273 Congress, East End Lofts

Submission of Revised & Additional Information

Summary of Design changes in response to Historic Preservation Workshop

ROOF PLAN
SCALE: 1/8" = 1'-0"

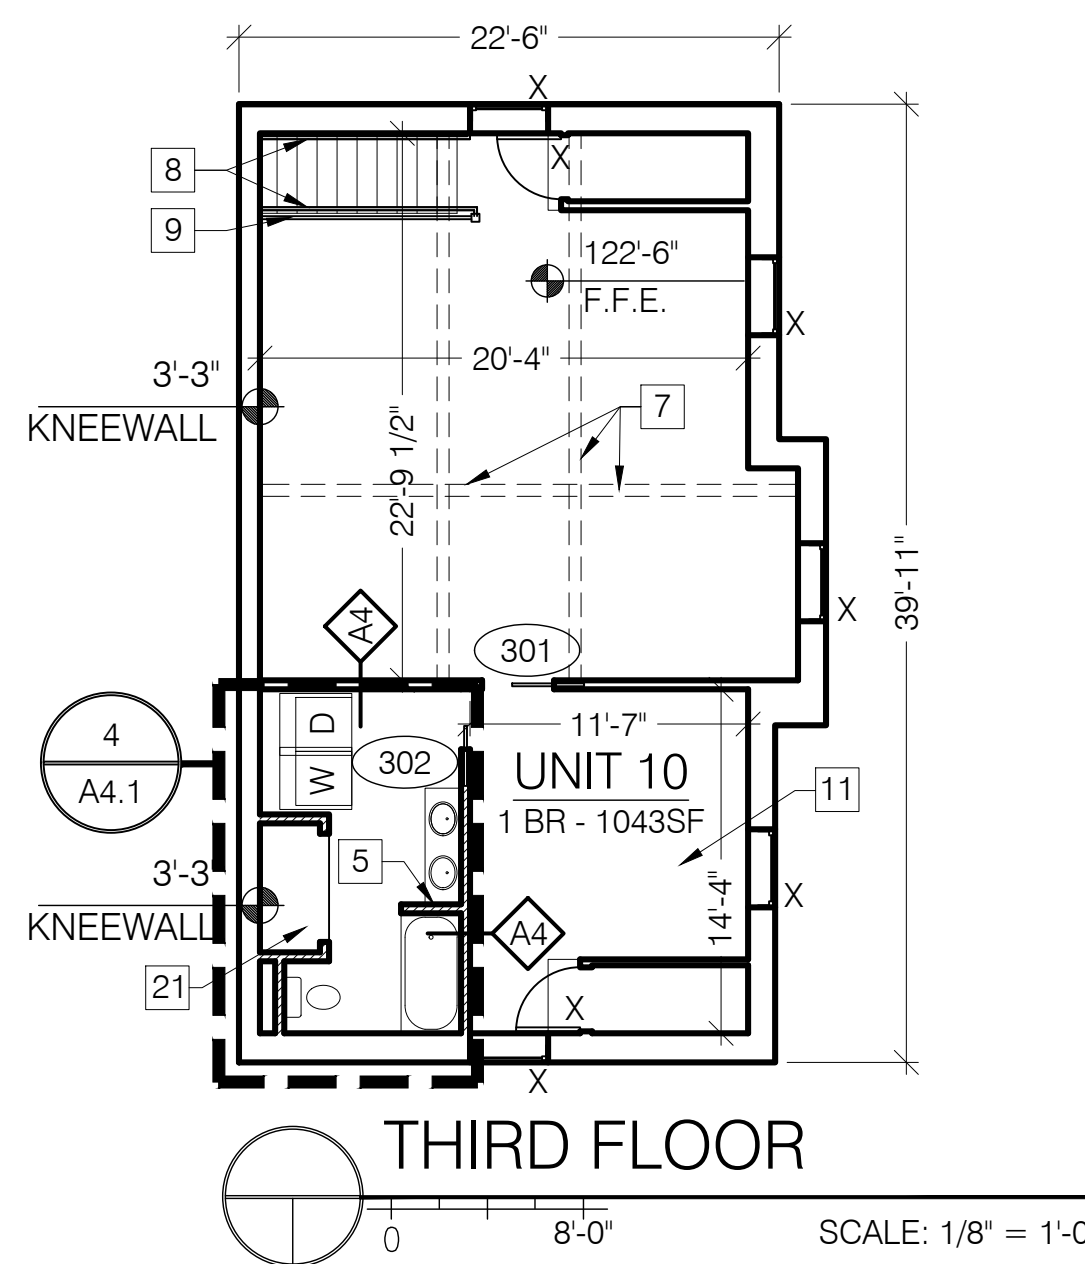
Description	Reference
1	Proposal initially included a 6' tall partition between the two patios. Proposal now included only a railing between front patios.	Attached renderings, A2.1
2	Railings on patio were initially proposed to be galvanized finish with a wood composite arm rest. Proposal now calls for painted finish to match other metals on building, and no arm rest.	Attached renderings, A8.2
3	Patio doors were initially proposed to have un-arched tops with transom infill. Doors will have arched top rails that are custom made for the existing arched masonry openings.	Attached renderings, A2.1
4	Fire escape will be removed from front of building as part of the proposed renovation.	A2.1
5	Patio lighting fixture has not yet been chosen but fixture will be of the pathway light or aisle light style, and will be mounted below parapet to light patio surface only.	
6	HVAC vents are shown on elevations and roof plan. Grouping of vents is not always feasible as some vents are intakes and others are exhausts. Vents have been located in an orderly manner to the highest degree possible.	A1.2, A2.1
